**Washington State
Department of Transportation**

May 7, 2014

Subject: RZ-14-00001 – Butler Rezone
SR 903 Spur milepost 0.35 vicinity left

BUTLER STORAGE  
SITE PLAN  
SR970 CLE ELUM, WASHINGTON

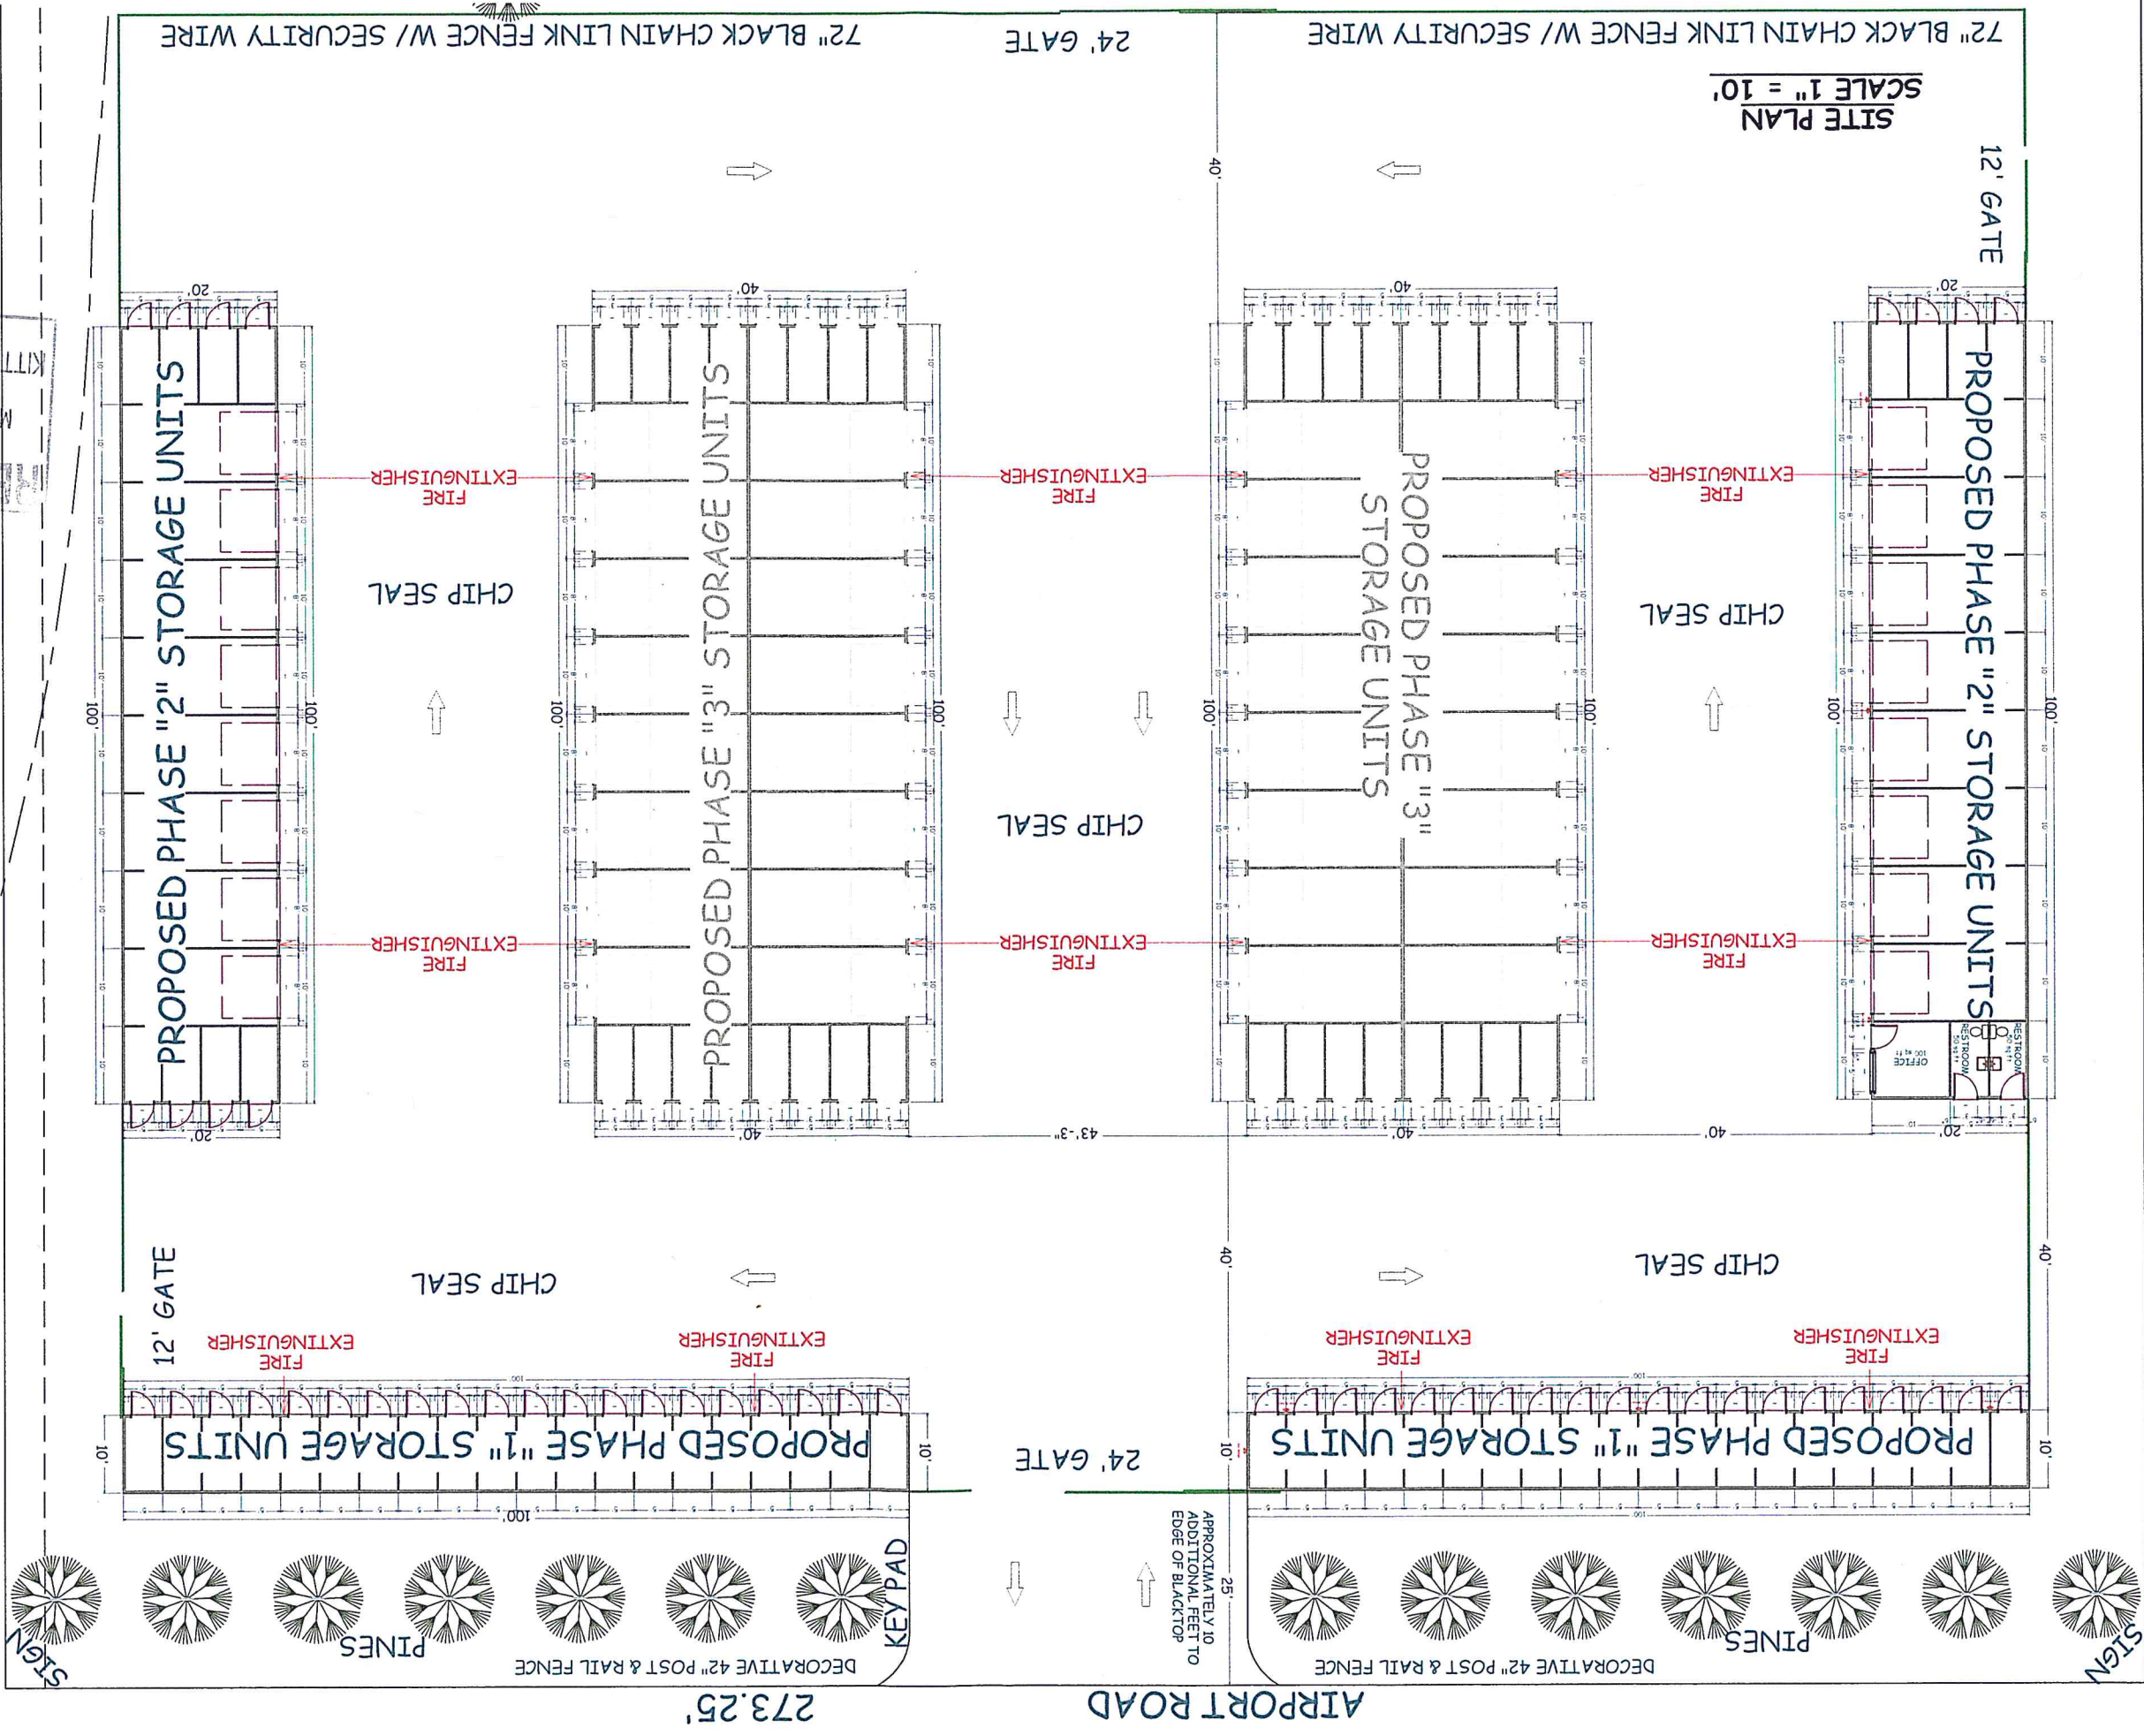
- The subject property has frontage along both Airport Road and the State Highway 903 Spur (SR 903 Spur). SR 903 Spur is a Class 3 access managed highway with a posted speed limit of 45 miles per hour. The applicant proposes all access from Airport Road. WSDOT is in agreement. For the safety and security of the highway, no direct access to the SR 903 Spur will be allowed.

Future access to the SR 903 Spur will only be allowed when a two-way left turn lane is built on the spur between the SR 903 and SR 970 intersections. There is no State funding for this improvement and the cost is anticipated to be paid for by the developer(s).

- Any proposed lighting should be directed down towards the site, and away from the SR 903 Spur.
- Stormwater and surface runoff generated by this project must be retained and treated on site, and not be allowed to flow onto WSDOT rights-of-way.
- All loads transported on WSDOT rights-of-way must be within the legal size and load limits, or have a valid oversize and/or overweight permit.
